Medworth Energy from Waste Combined Heat and Power Facility

PINS ref. EN010110
Document Reference: Vol 9.20
Revision: 7.0
Deadline 7
August 2023

Schedule of Changes (Deadline 7)

**Figure 4.1**  
**Proposed drainage strategy for Construction Phase**

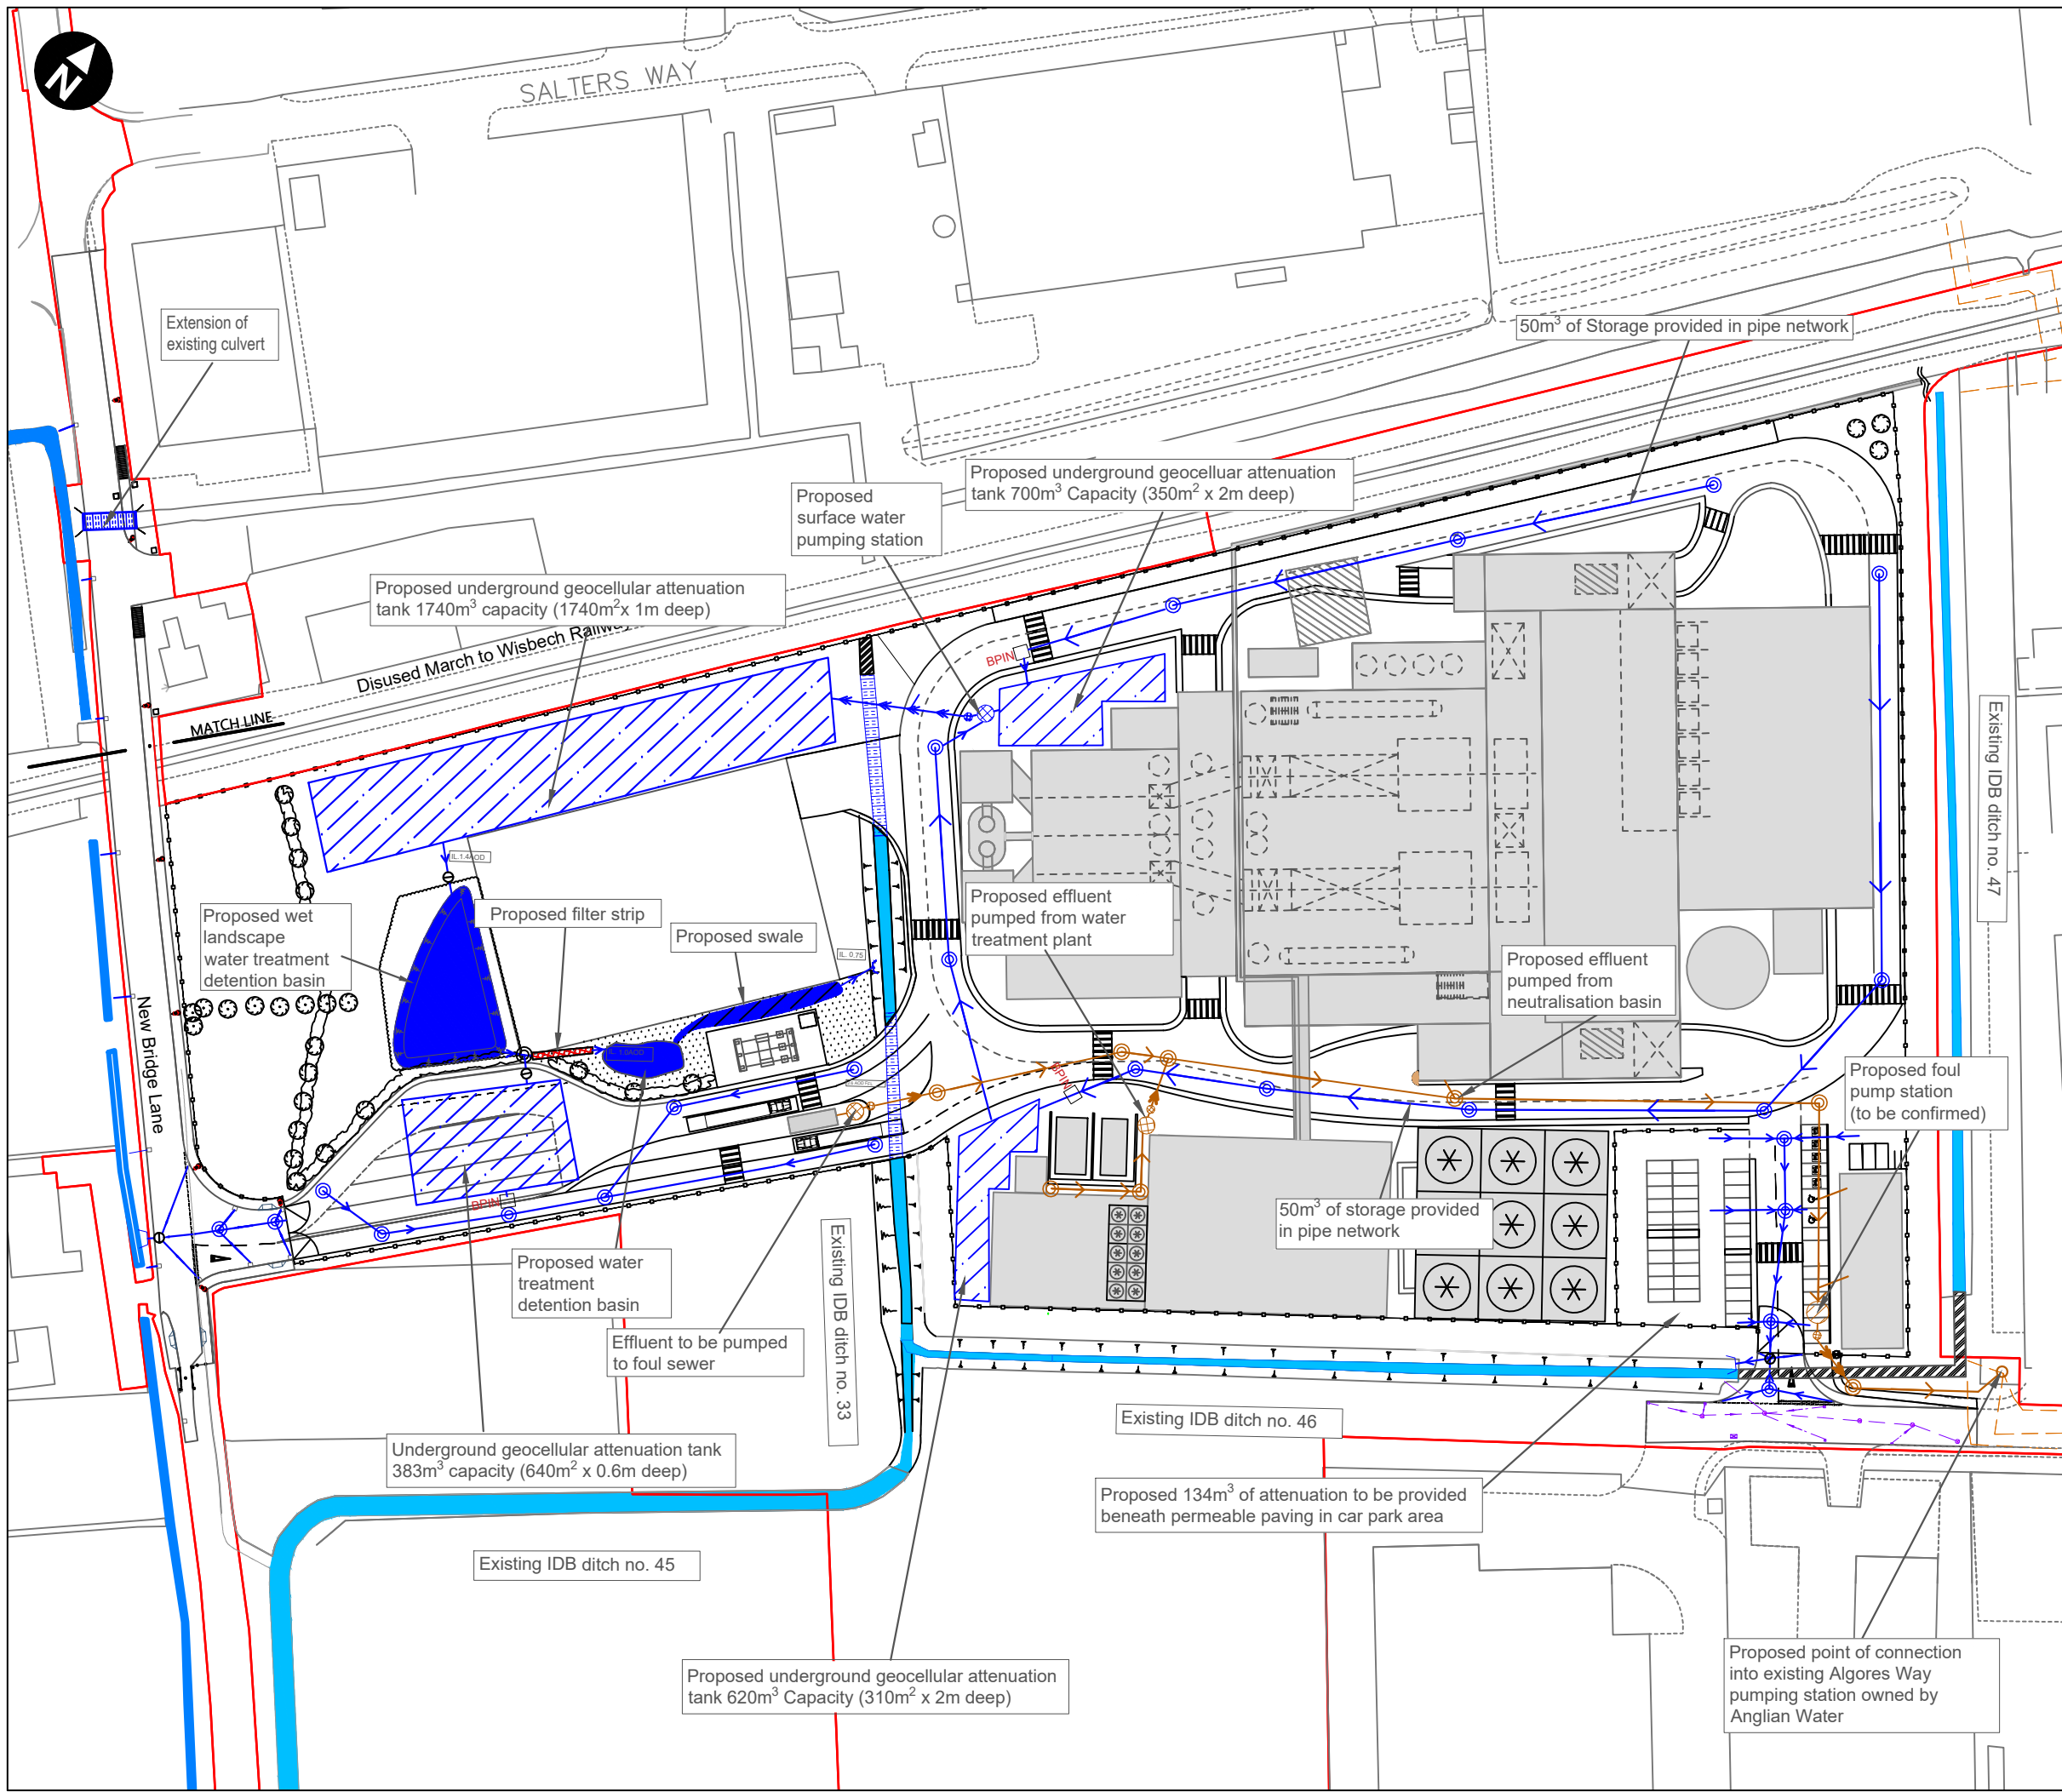
Document Updated	Change	Reason for change	Deadline submitted	Relevant Document version
	<p><u>Section 6 (Summary)</u> Minor amendments to the text to reflect the amendments to the Walsoken Substation and frequency for the replacement of straw bales text.</p> <p><u>Figure 4.1</u> Amendment of 0.5m high earth bund around the perimeter of the northern Efw area and TCC (i). Increase storage capacity of 3 No attenuation basins in TCC (ii).</p>			
Volume 7.9 Outline Flood Emergency Management Plan [APP-100]	Paragraph 2.1.3, Table 5.1 - emergency planners to be notified of any residual risks.	Environment Agency (EA) Relevant Representation [RR-014].	Deadline 1	Rev 2
Volume 7.9 Outline Flood Emergency Management Plan [APP-100]	Paragraph 1.1.3 – the Cambridgeshire and Peterborough Local Resilience Forum will be engaged in the production of the final plan.	FDC and CCC Joint Relevant Representation [RR-002 - RR-003].	Deadline 1	Rev 2
